Your Ref 2024/91828
Our Ref CRTR-PLAN-2024-42295
Wednesday 14 August 2024

Proposal: Demolition of existing hotel restaurant and erection of additional hotel bedrooms with breakfast room and alterations to the car park and associated works

Location: Premier Inn, St. Andrew's Road, Huddersfield

WEST ELEVATION

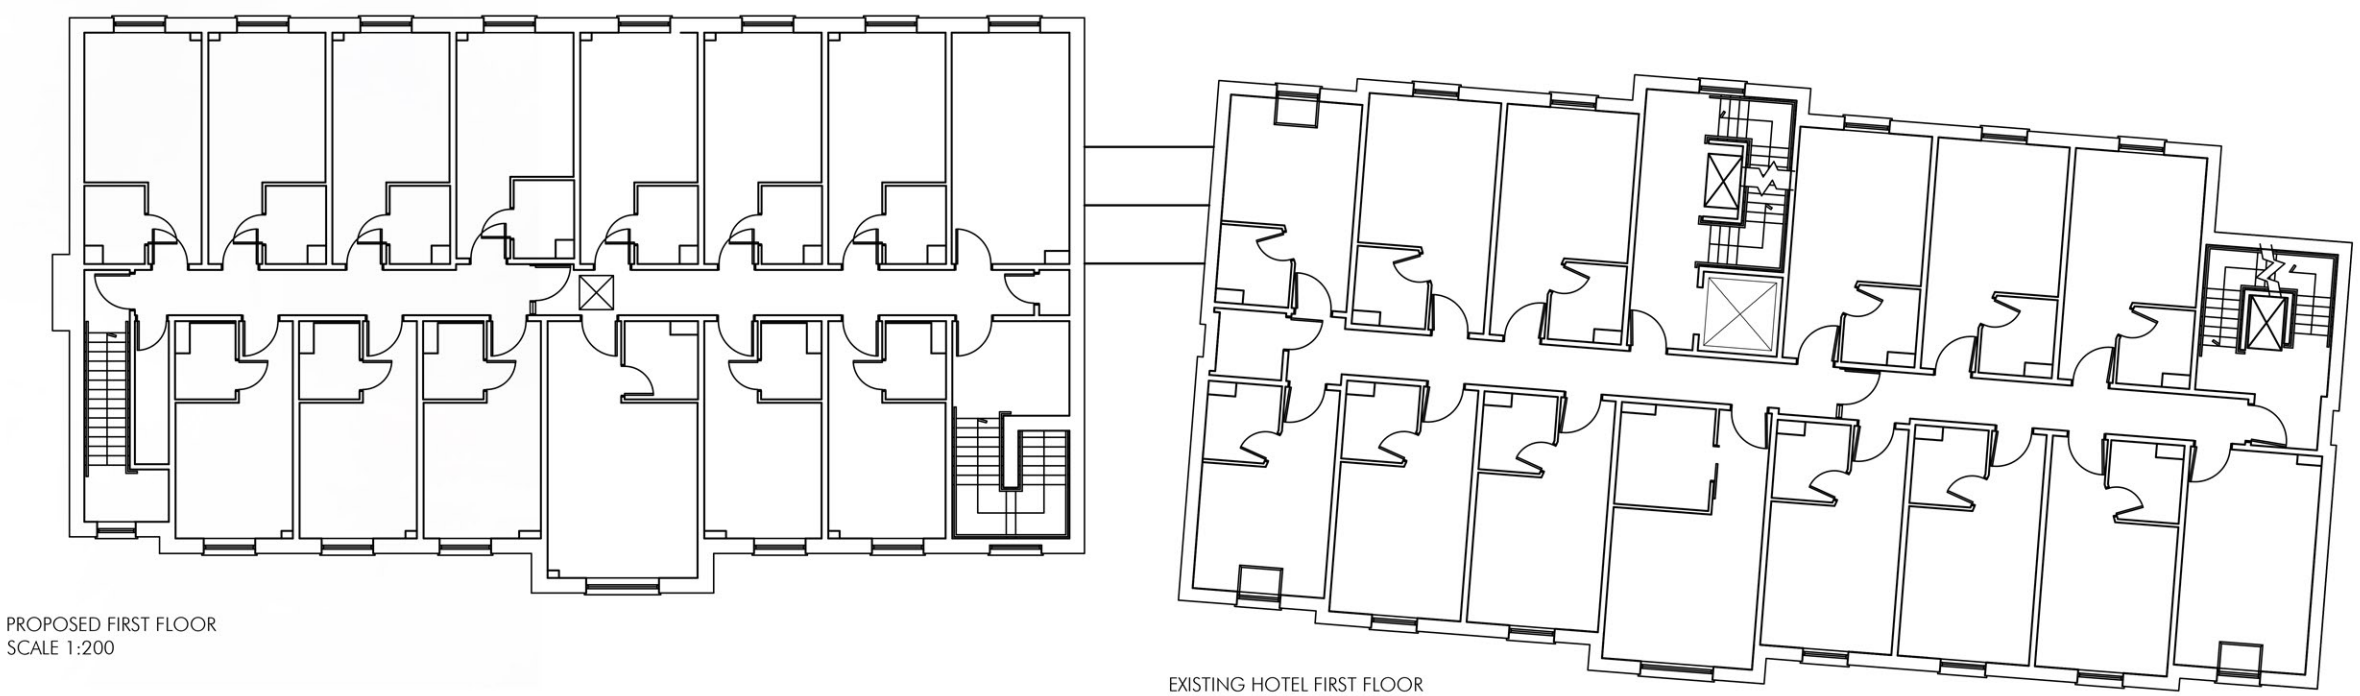
We do have significant concern that the proposed west elevation would only feature a single fire egress, resulting in less active space and decreased passive surveillance of the canal. This has the potential to lower the quality and prominence of the canal and the basin in this setting.

We request that **amendments are sought to provide a more active frontage to the west**. For example, the re-orientation of rooms (or provision of additional window openings on the west elevation) could significantly enhance the appearance of the building and its relationship with the canalside environment.

TITLE: Propsoed Drainage GA

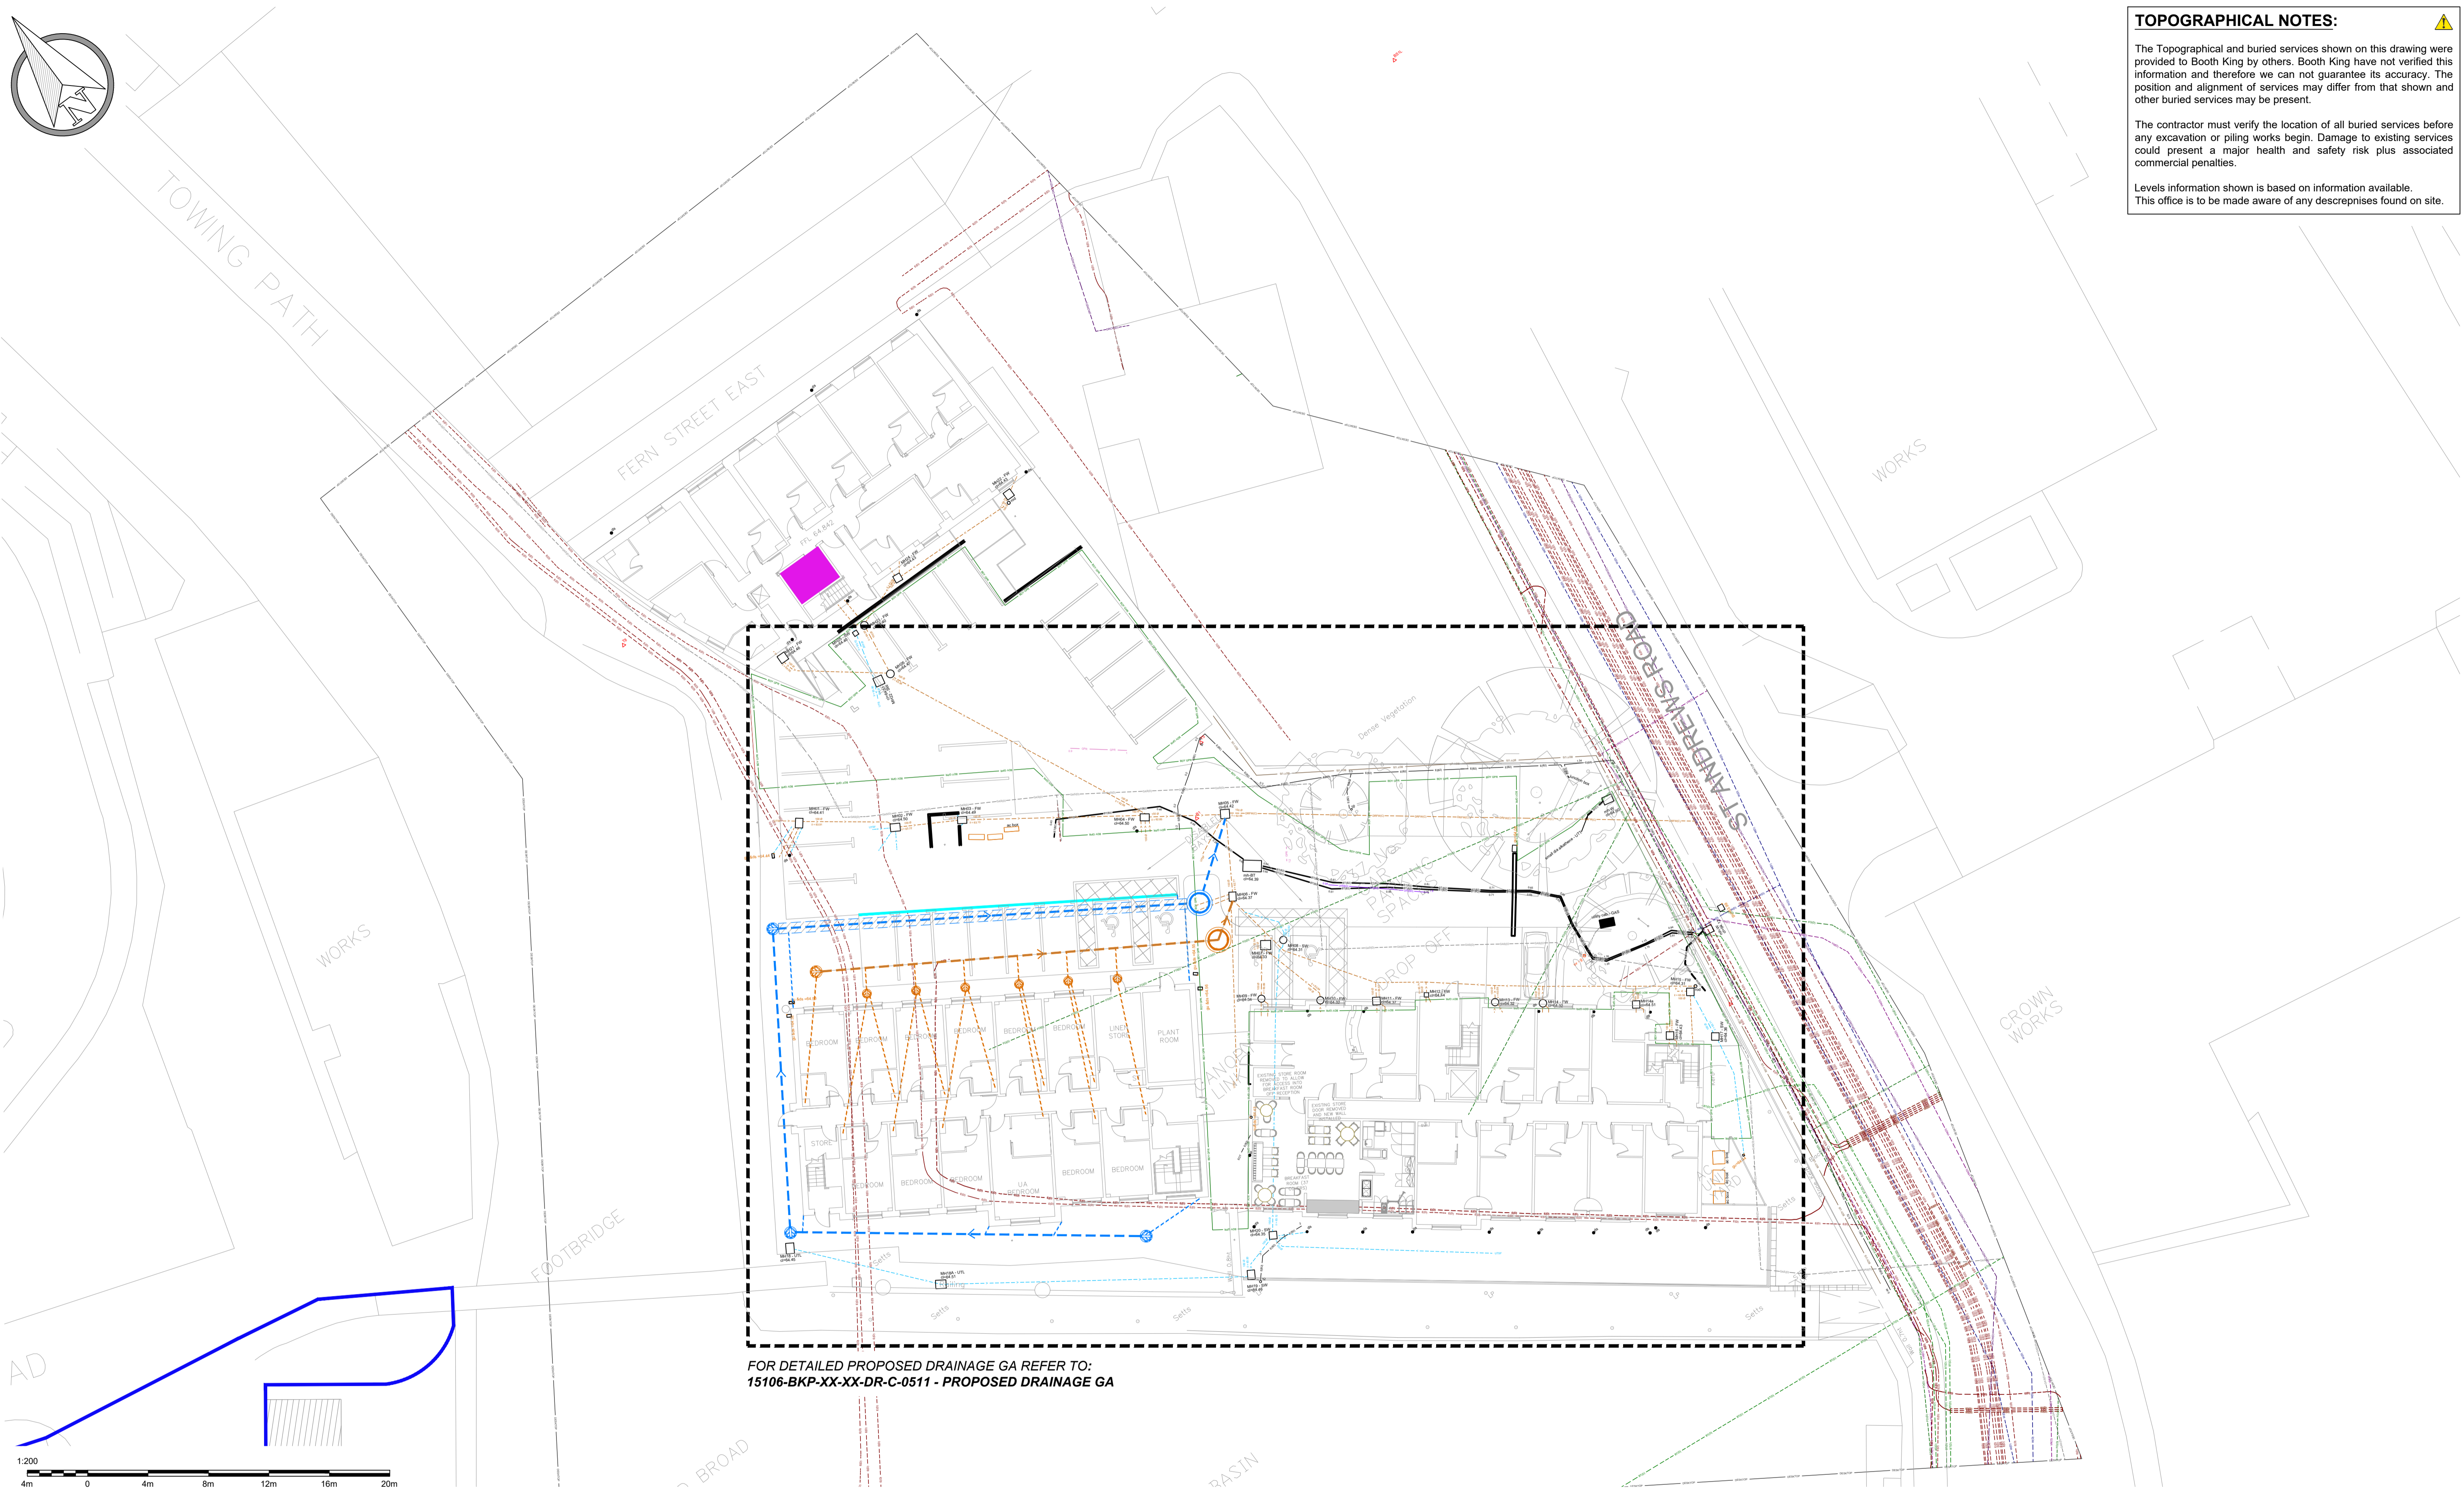
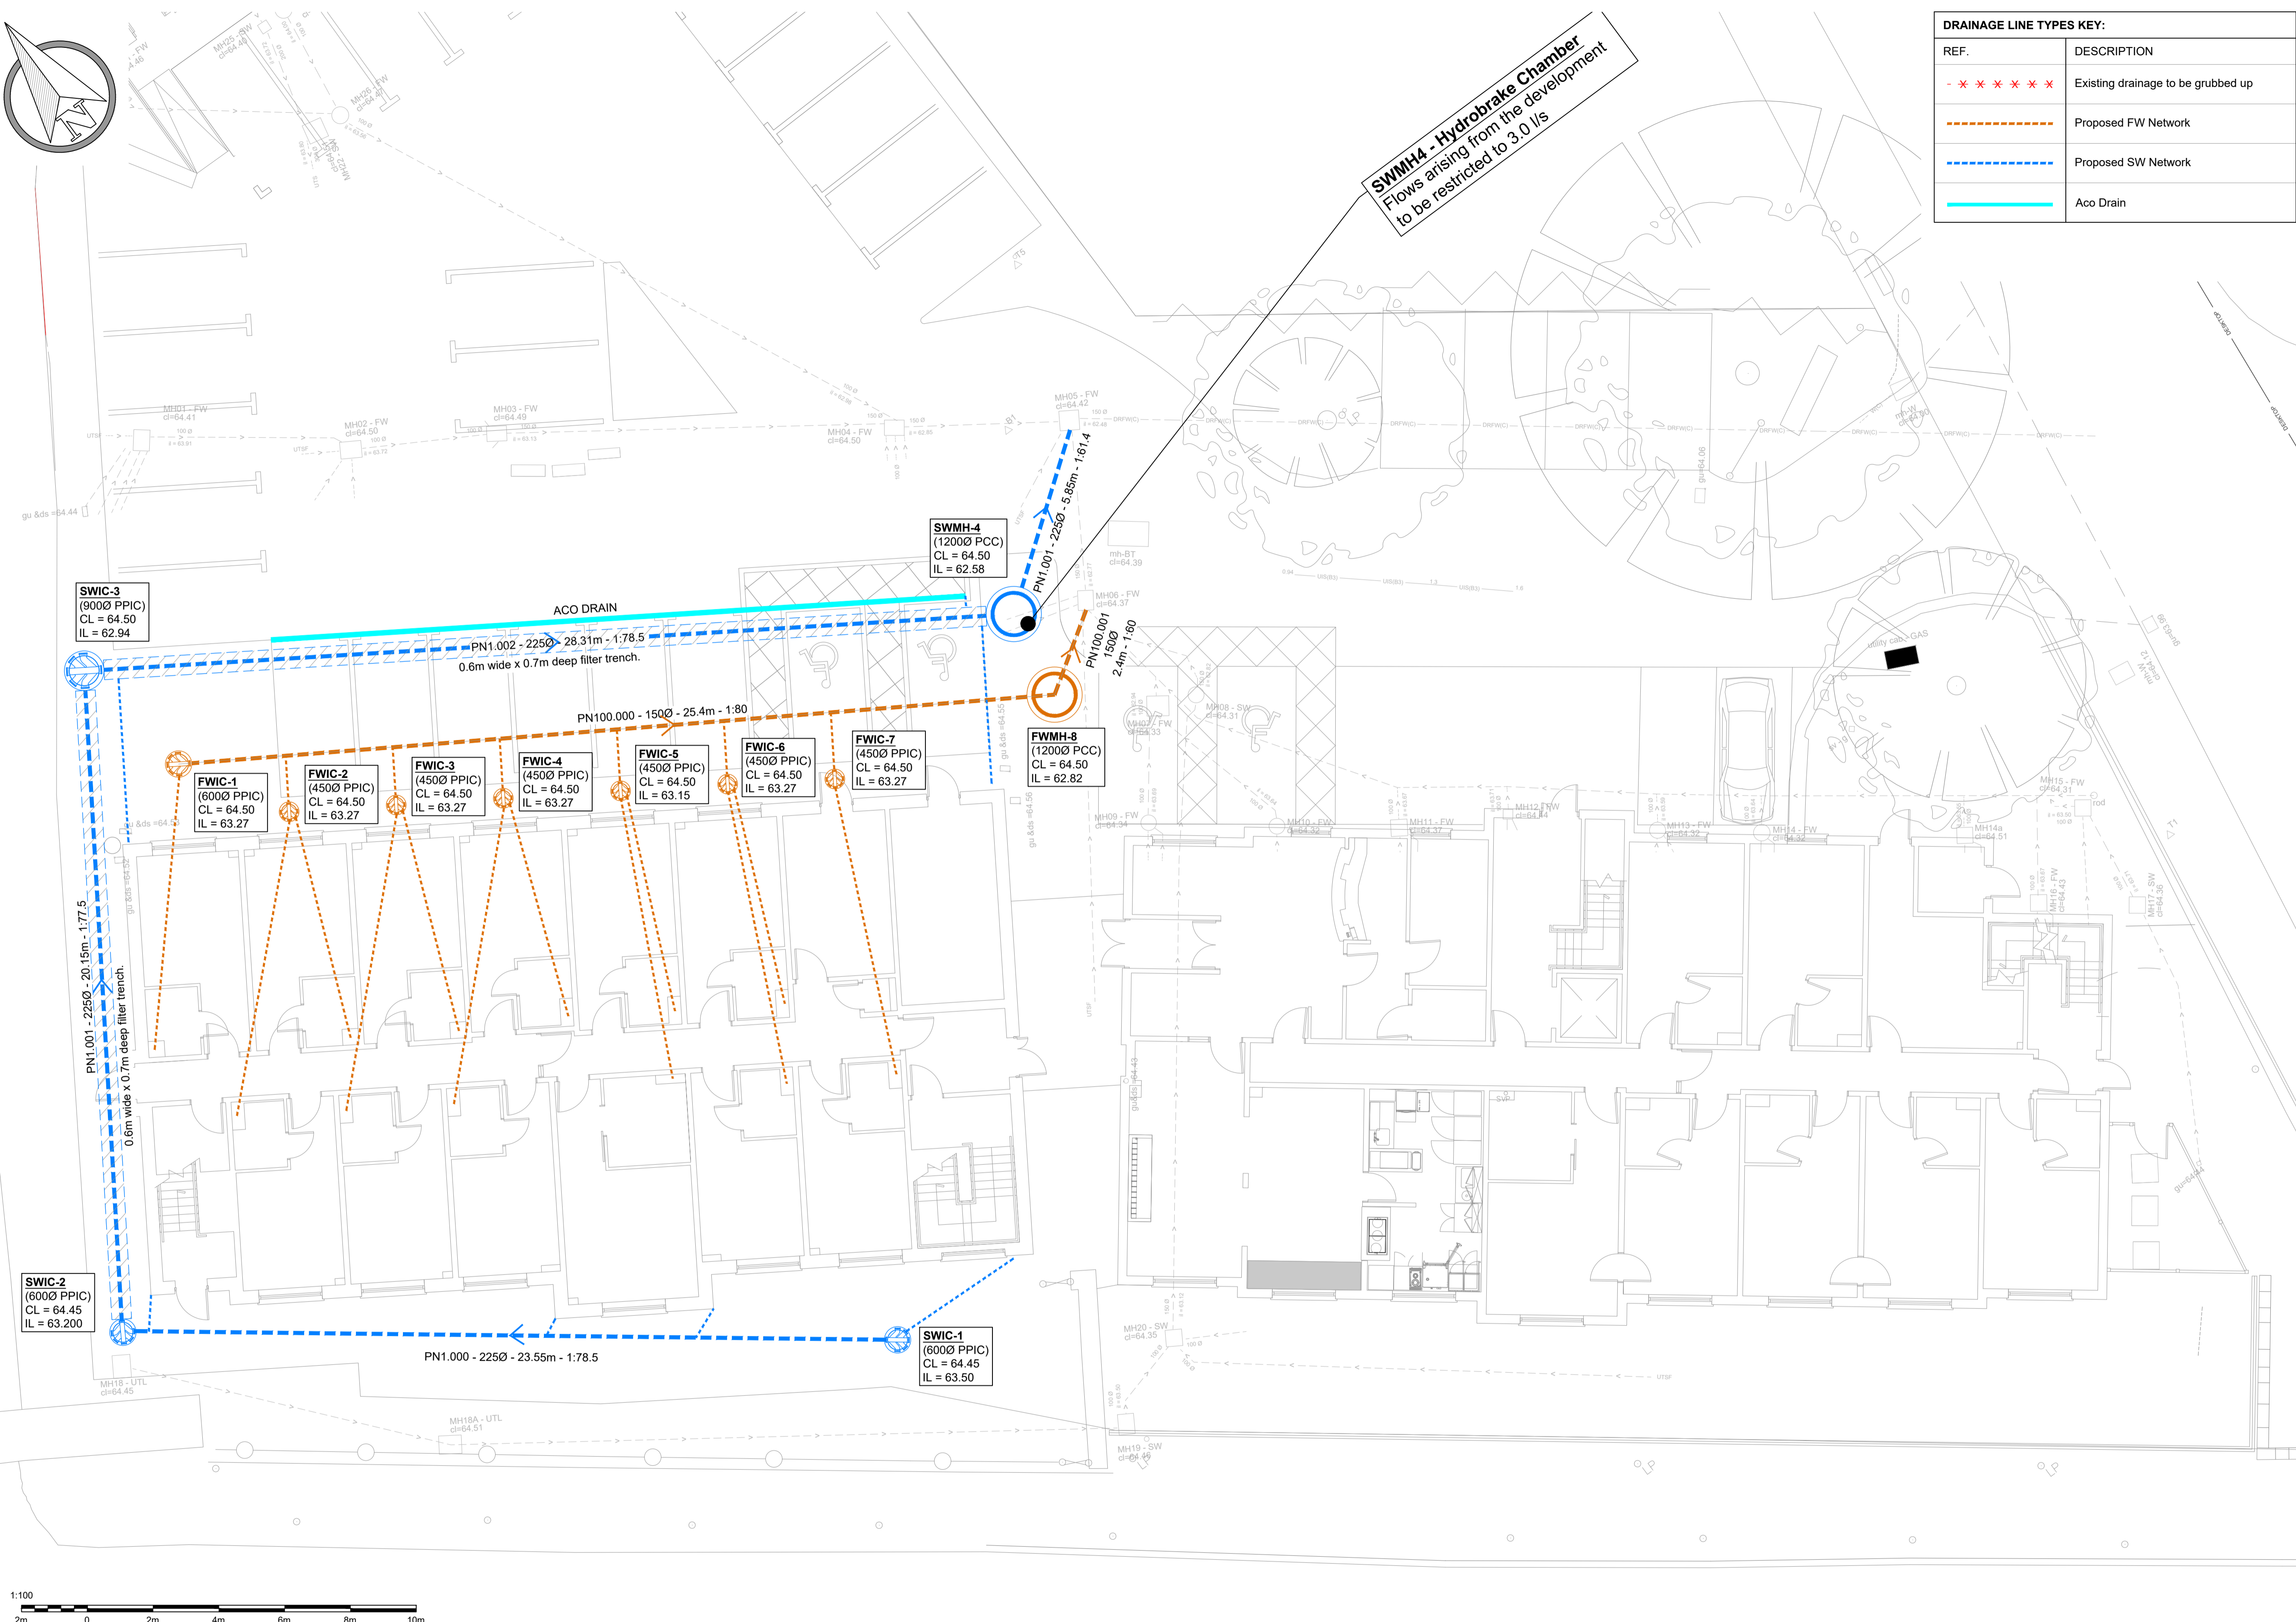
Works to excavate land for the building and new drainage pipes have the potential to undermine the canal wash wall, which could compromise the stability of this structure. In addition, loading from any construction plant and equipment has the potential to compromise the stability of this structure.

To safeguard the stability of the wash walls, plant and equipment should be appropriately sited away from the canal edge where possible. We also advise that the depth of any excavation works are monitored to reduce the impact on the wash walls.
